CITY OF ALBUQUERQUE

February 13, 2015

Re: 608 8th St. NW
Grading & Drainage Plan
Engineer's Stamp dated: 1-19-14 (J14D174)

TOWNHOUSES FOR LOBBEREGET GRADING AND DRAINAGE PLAN

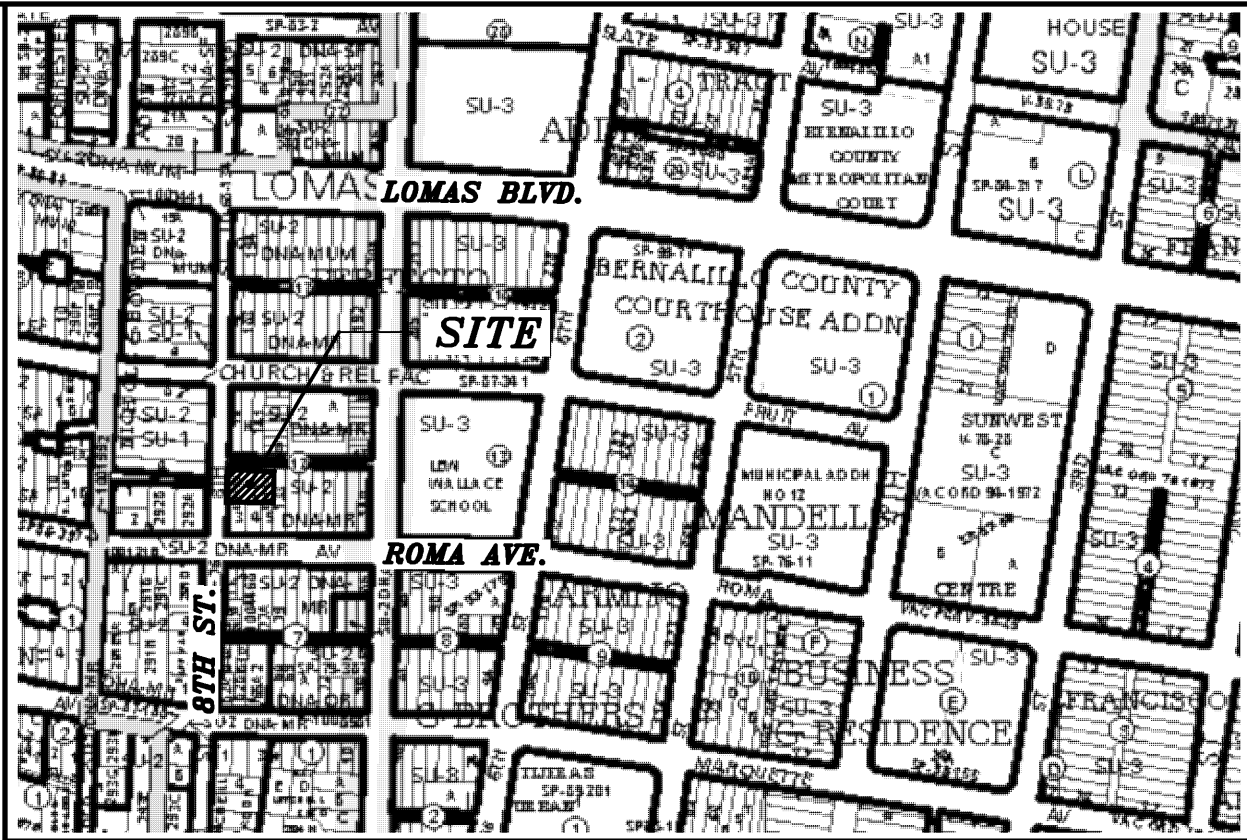
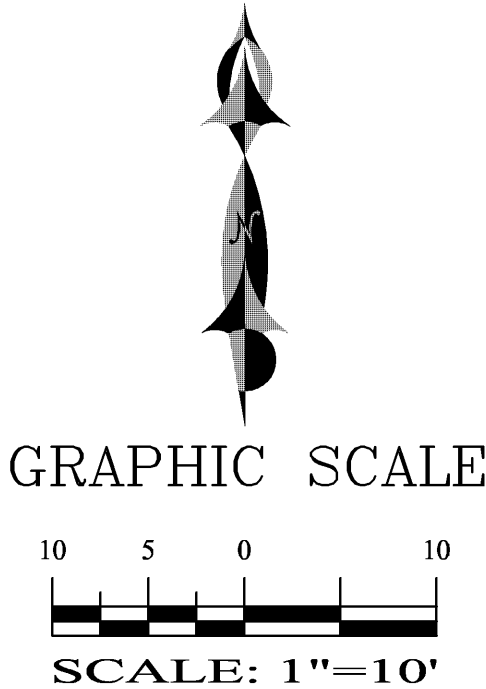
- Provide direction of roof flows. If flows are toward the front, how will these flows enter the ponding areas, and then exit the ponds toward the alleyway?
- Consider building #4 rebar spaced at three 3" on center to the wall openings.
- Build notes are needed for the new and existing sidewalks.
- Provide flow lines north of the ponds.
- Is concrete provided for the garage entry, if so, is the concrete matching the elevation of the paved alleyway?
